**MERITON TOWER**

22 November 2011

**S.75W MODIFICATION TO MP10\_0057 – RESPONSE TO ISSUES  
132-138 KILLEATON ST, ST IVES**

SITE SECTION B-B
SCALE 1:200

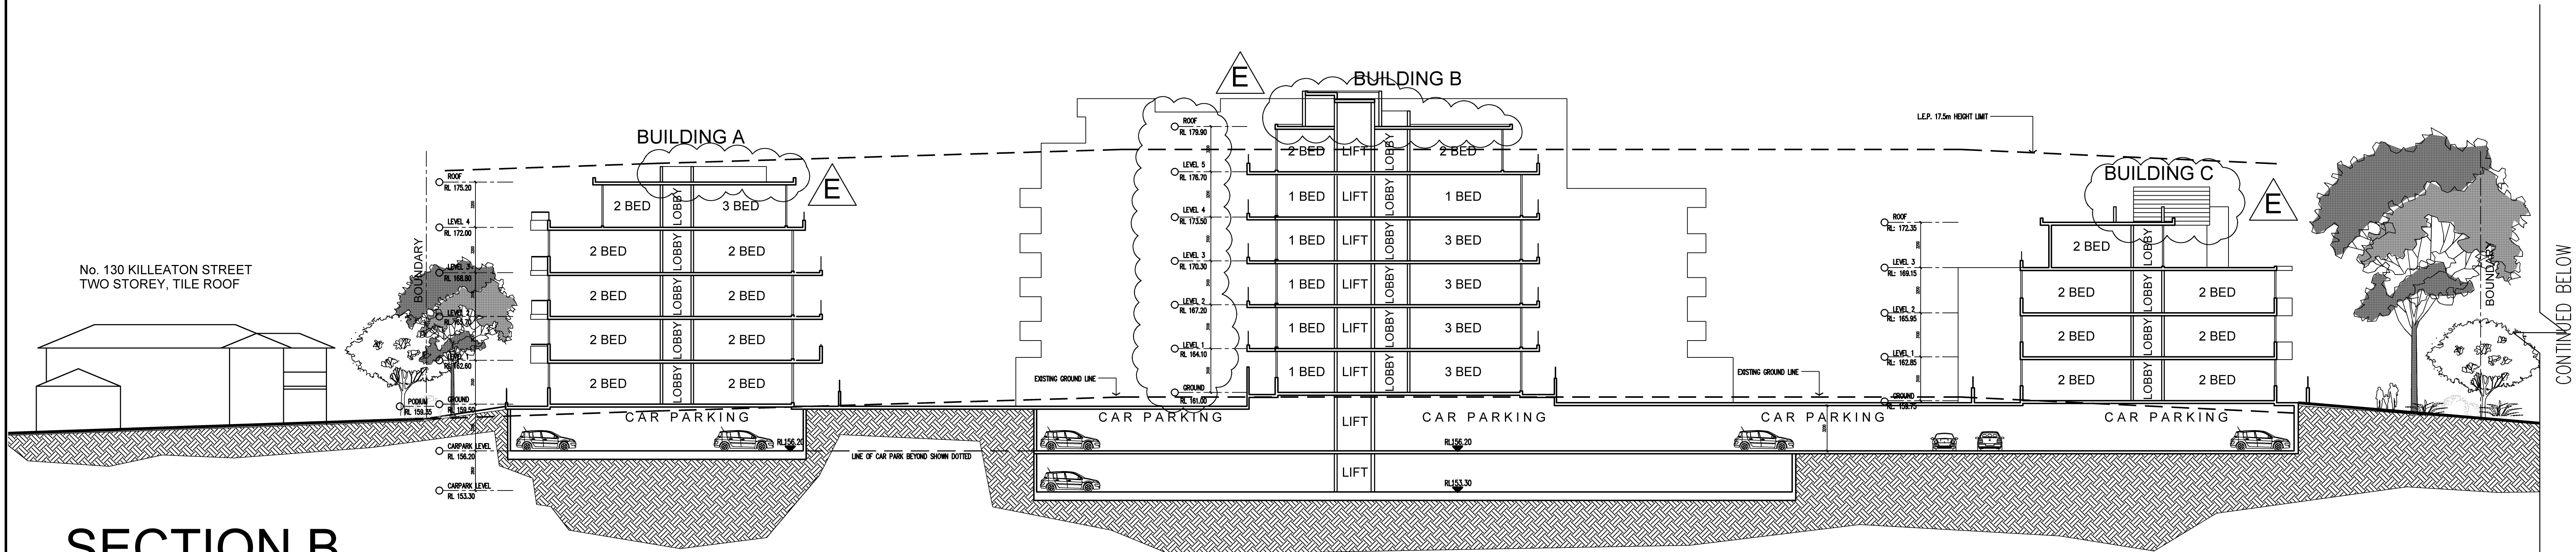
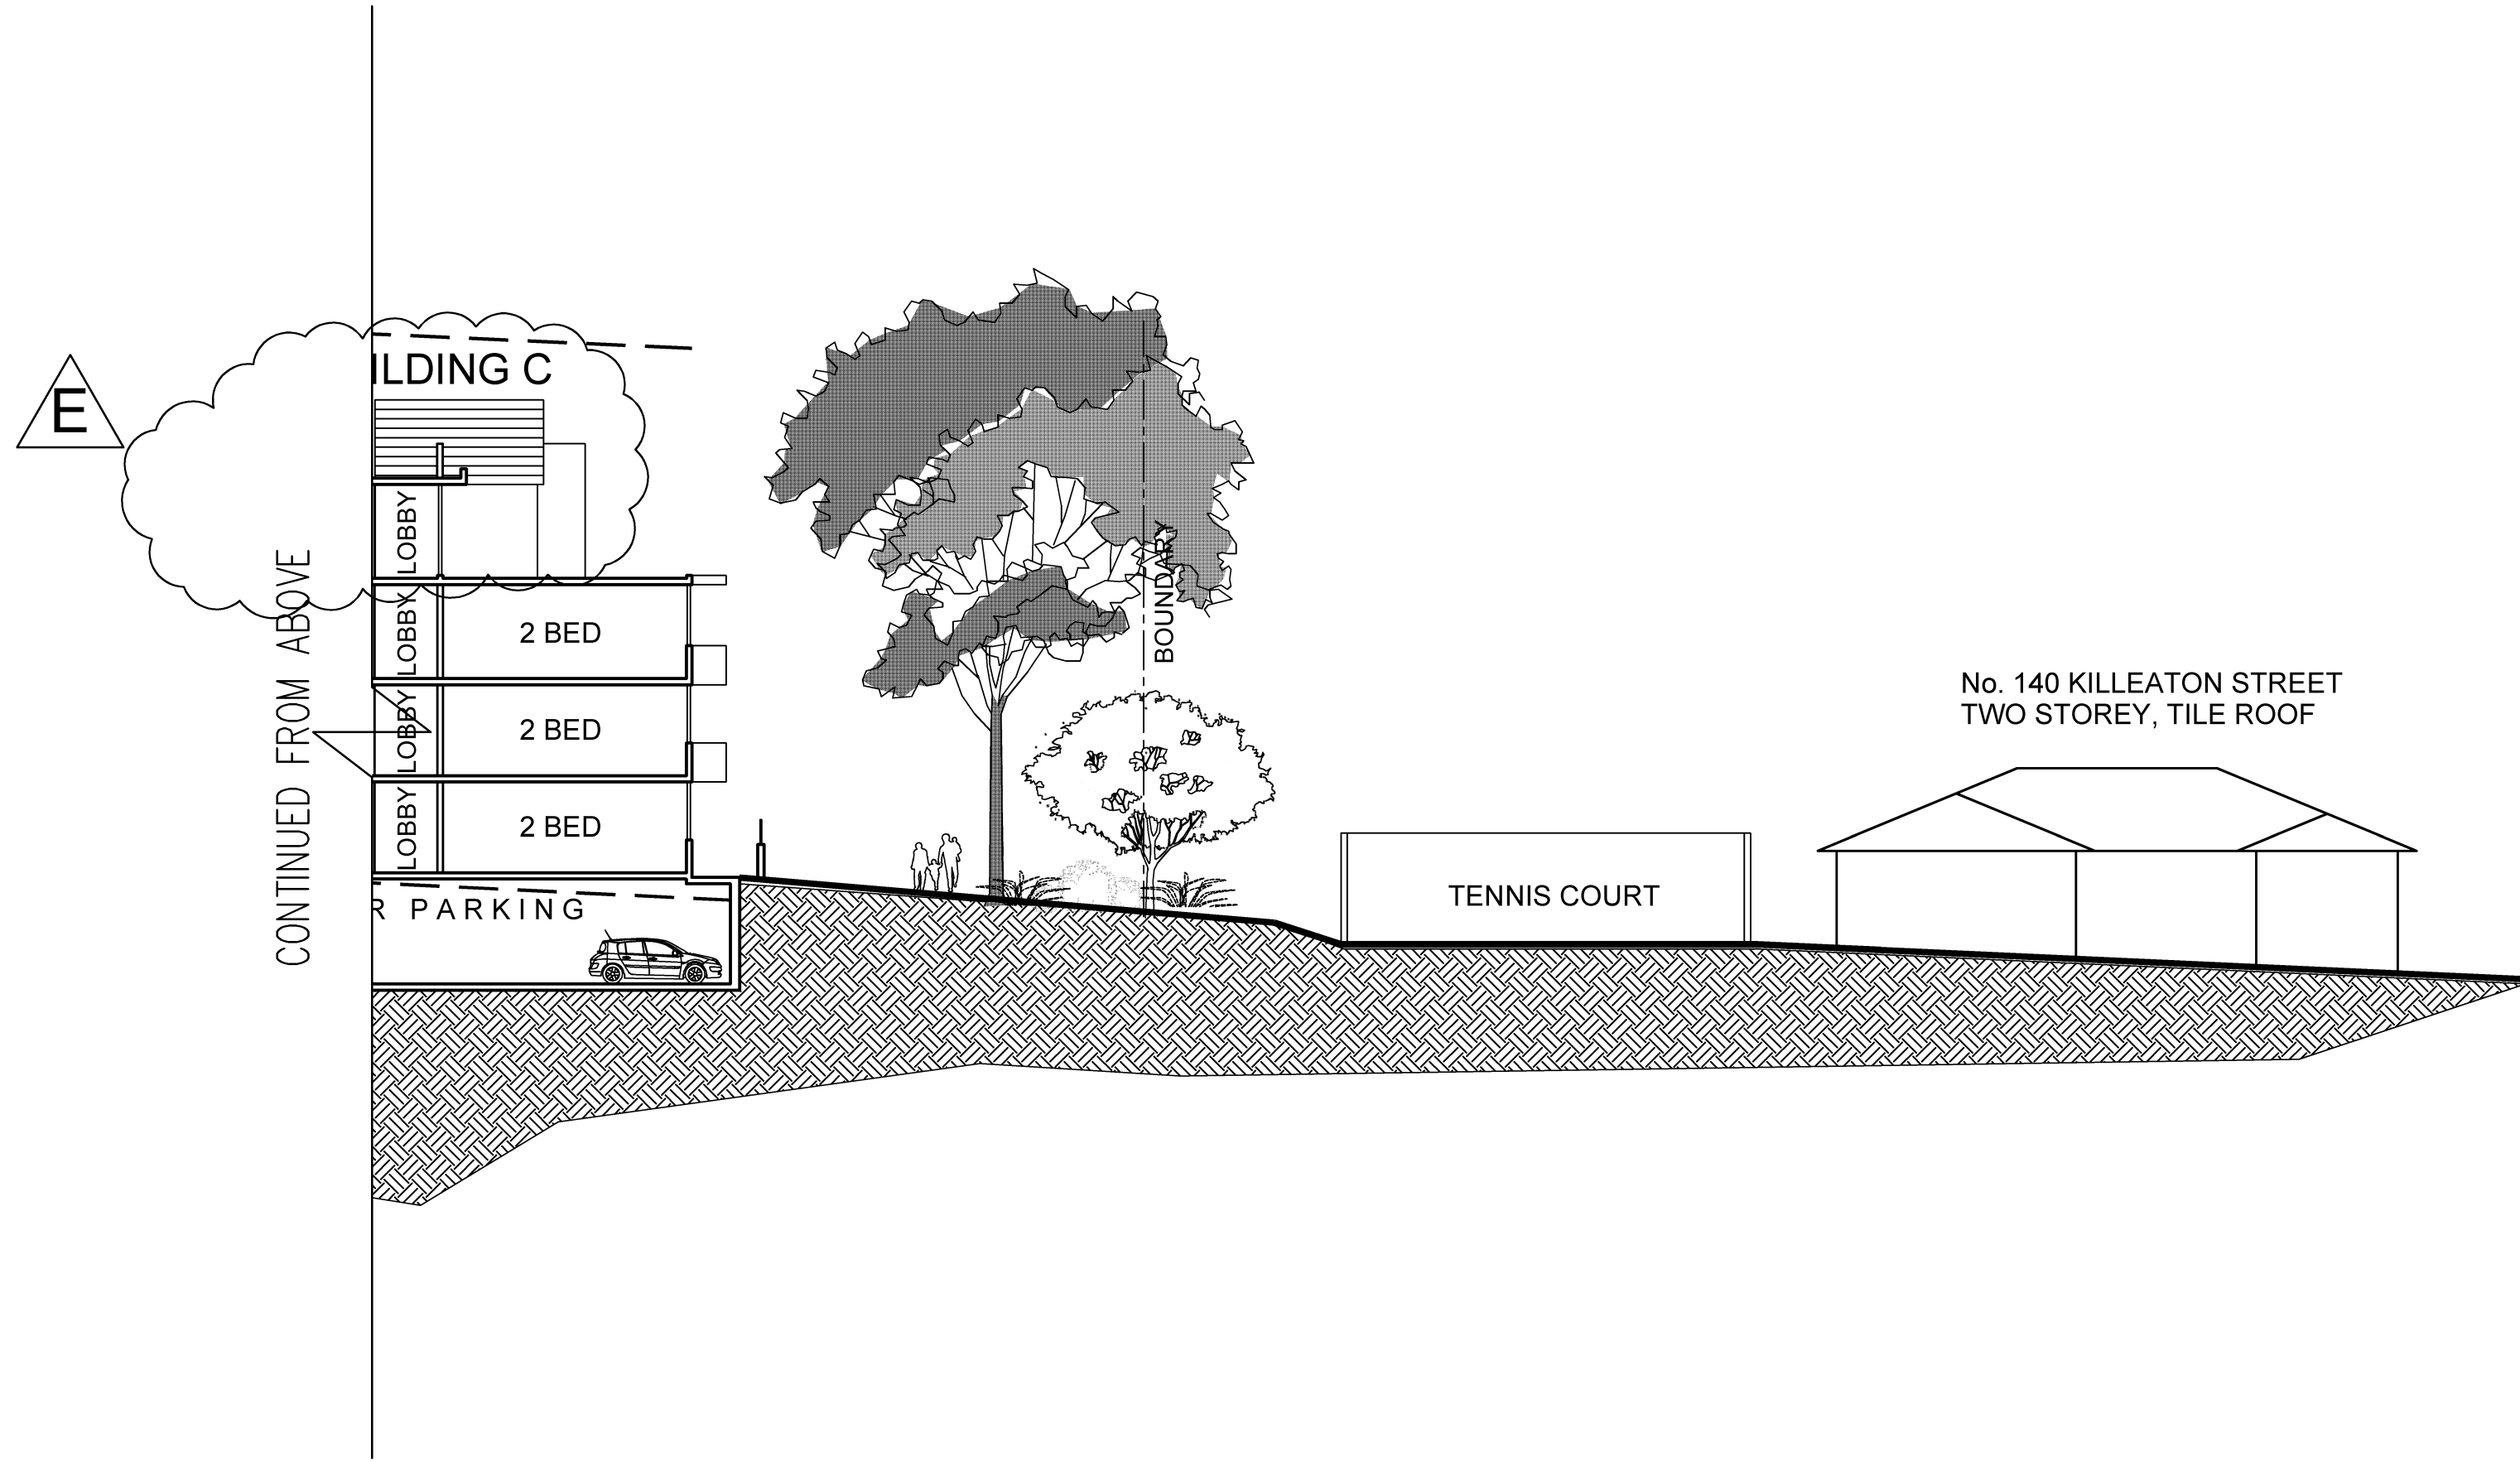
In response to Council's comments above we provide the following response. Firstly, the original plans submitted with the Modification have been reviewed and the overall building height has been substantially reduced. The plans have been amended to show a 100mm increase from levels 3 to the roof for Building B, where previously we proposed a 770mm increase in height.

This clause that Council is using to state that the roof plant rooms are creating another storey is not entirely correct. This clause means that any car parking or plant (including any combination of them both) that is more than 1.2m out of the ground would constitute another storey. Our modification does not seek to increase the height of carpark/plant at ground level. Block B is now only 100mm higher from Level 3 to the roof to accommodate the need of a "transfer slab" to take the weight of the building above. Without the transfer slab at this level, the building becomes structurally vulnerable, and is a necessary engineering requirement. The additional 100mm will not be visually perceivable within a 5 storey building.

DRAWING TITLE:
STAGE-1 LEVEL ROOF PLAN

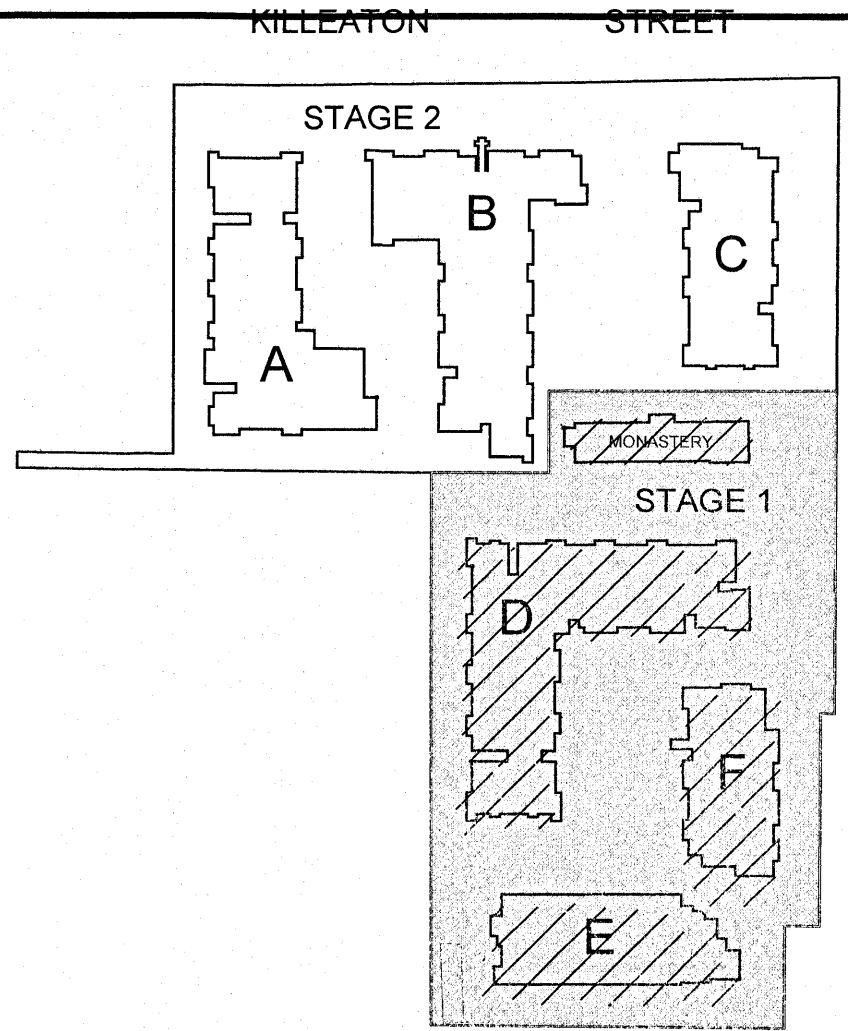
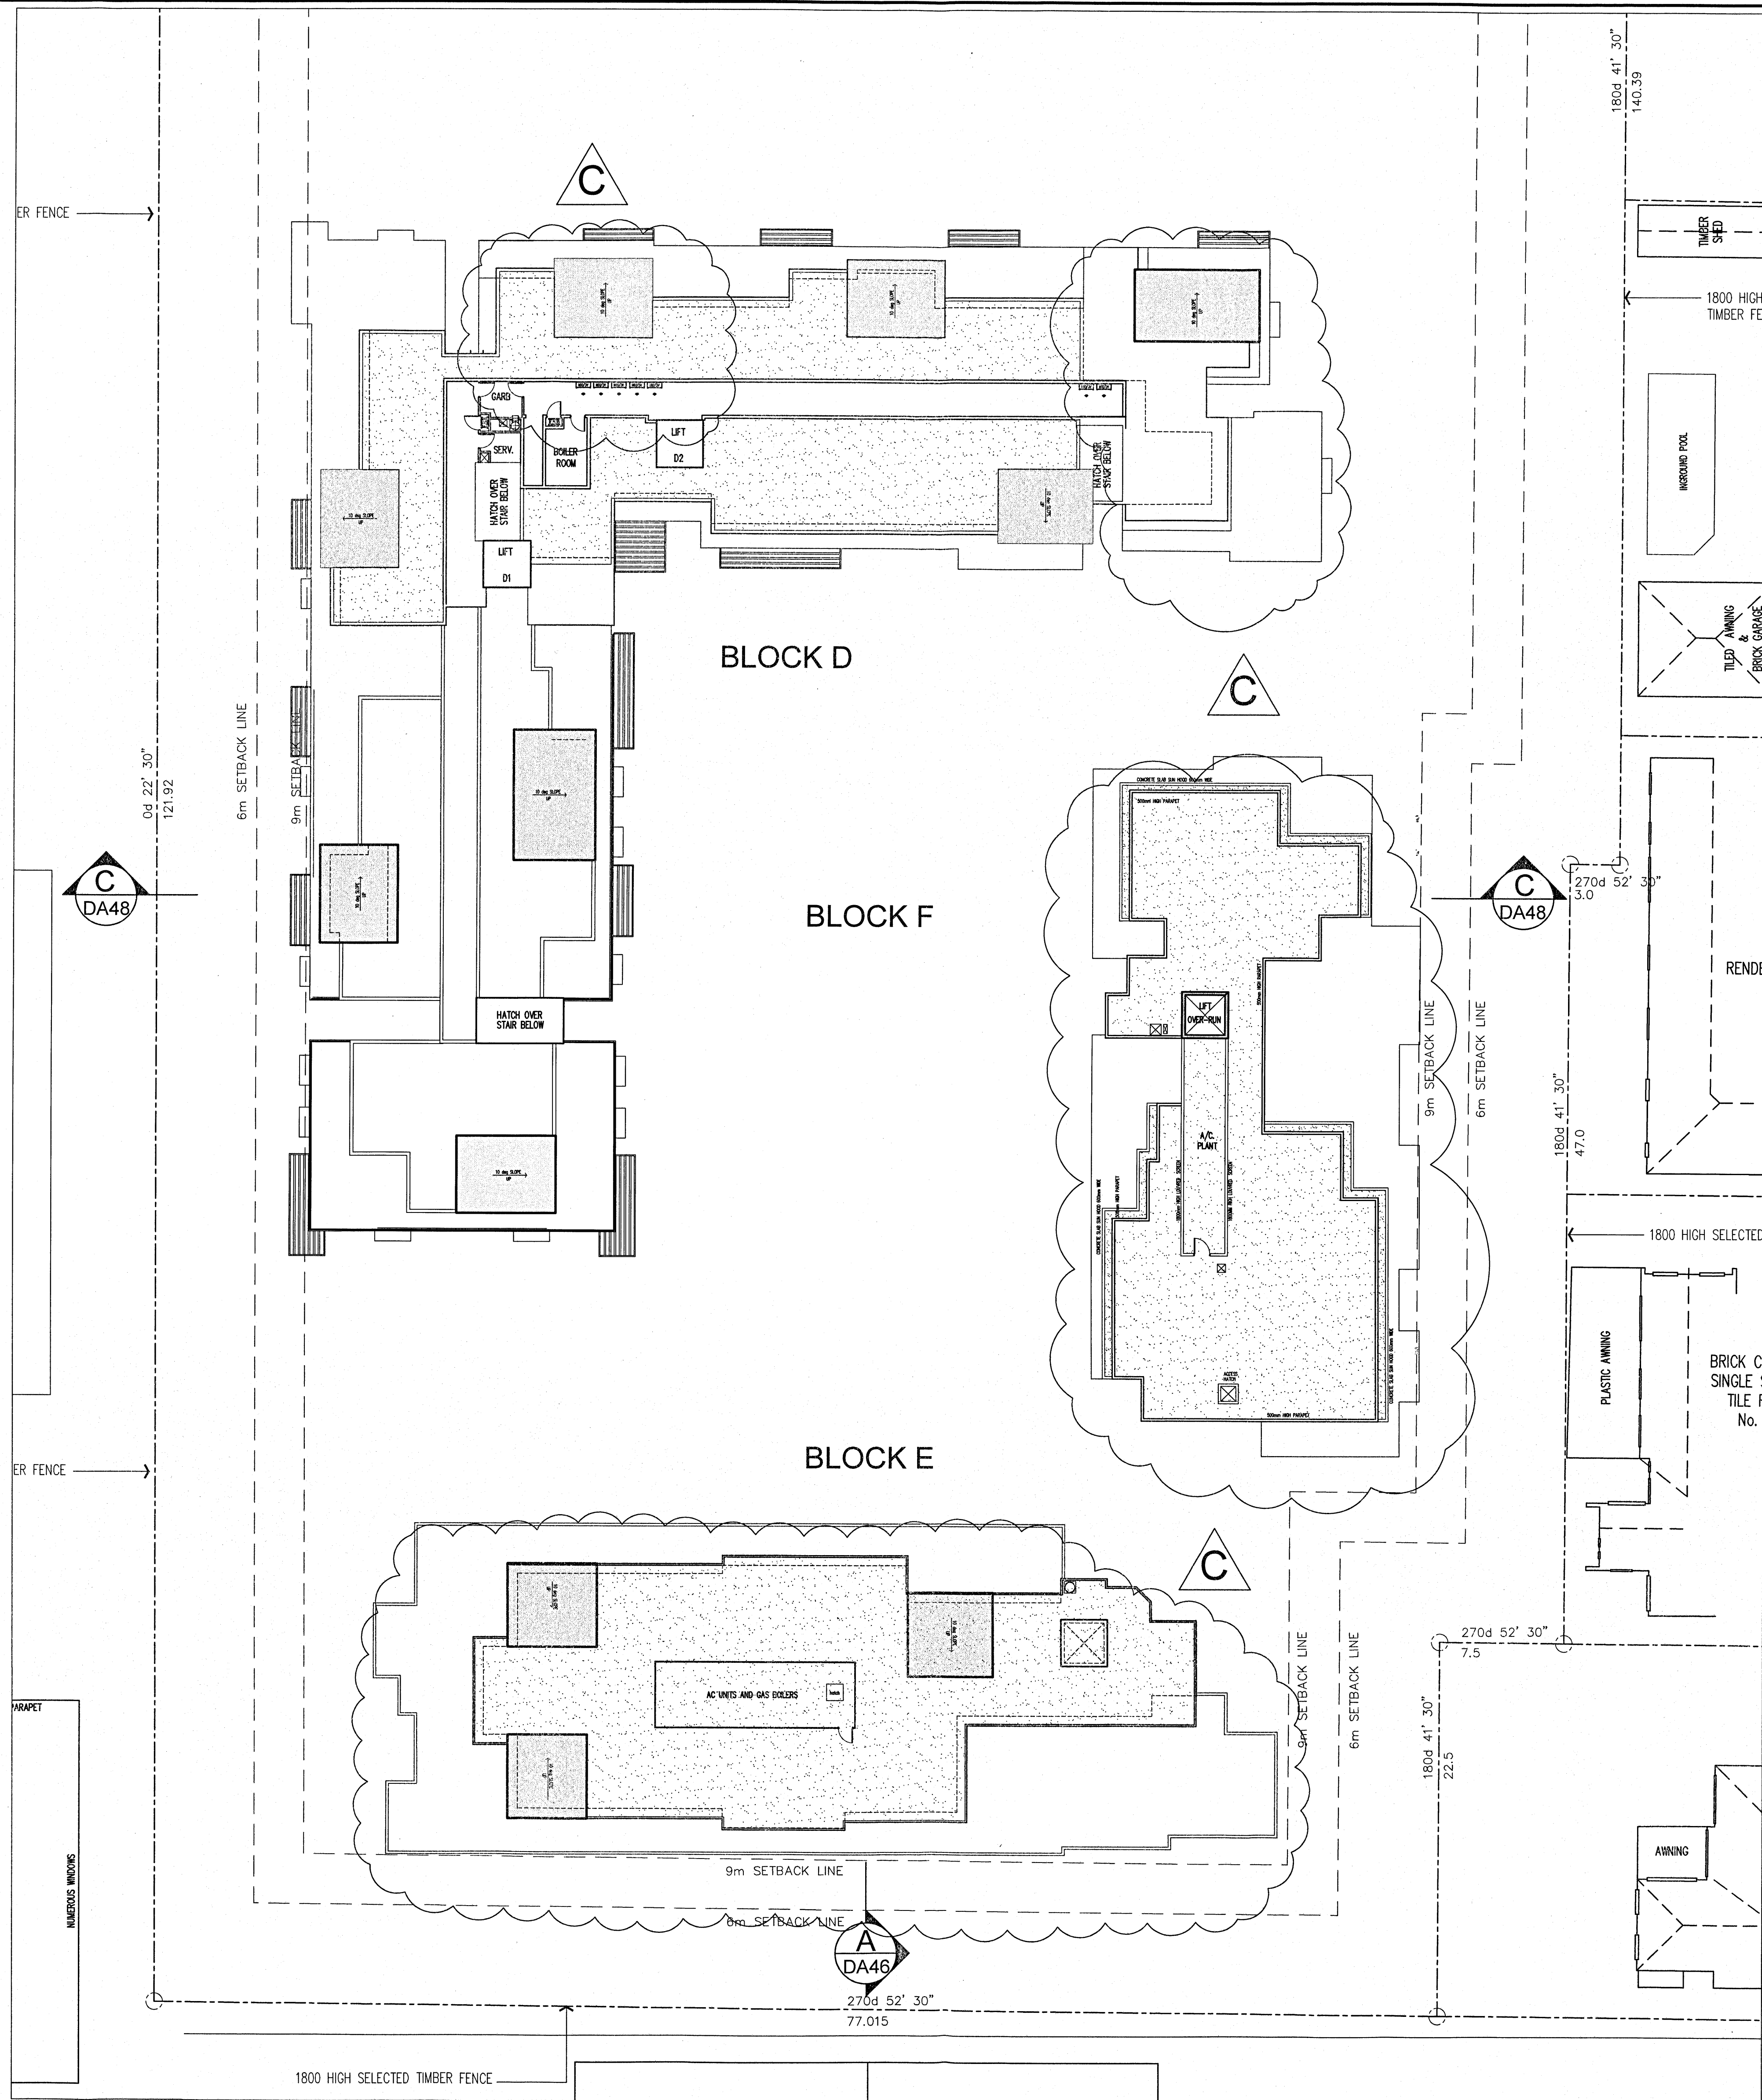
With regard to the roof plant, this is predominantly made up of boiler rooms required to operate hot water for the entire building. The additional lift height is required to comply with Work Cover requirements to allow enough room for a maintenance person to safely use the space between the lift shaft ceiling and lift carriage ceiling. Without this space, it becomes unsafe for the maintenance workers and there is the issue of how the lift carriage will be maintained in the long term. In this instance, it is a necessity to have the lift shaft higher than the approval.

As an example, the diagrams below show the before and after elevations of the boiler room (circled) and lift shaft on Blocks B and D. It is clear from the diagrams that the difference in the façade heights has not dramatically changed. Also if one looks at the roof plan, the boiler rooms and lift share are contained in the middle of the roof space and therefore cannot be viewed from ground level. This is shown in the attached perspectives (**Annexure 3**).
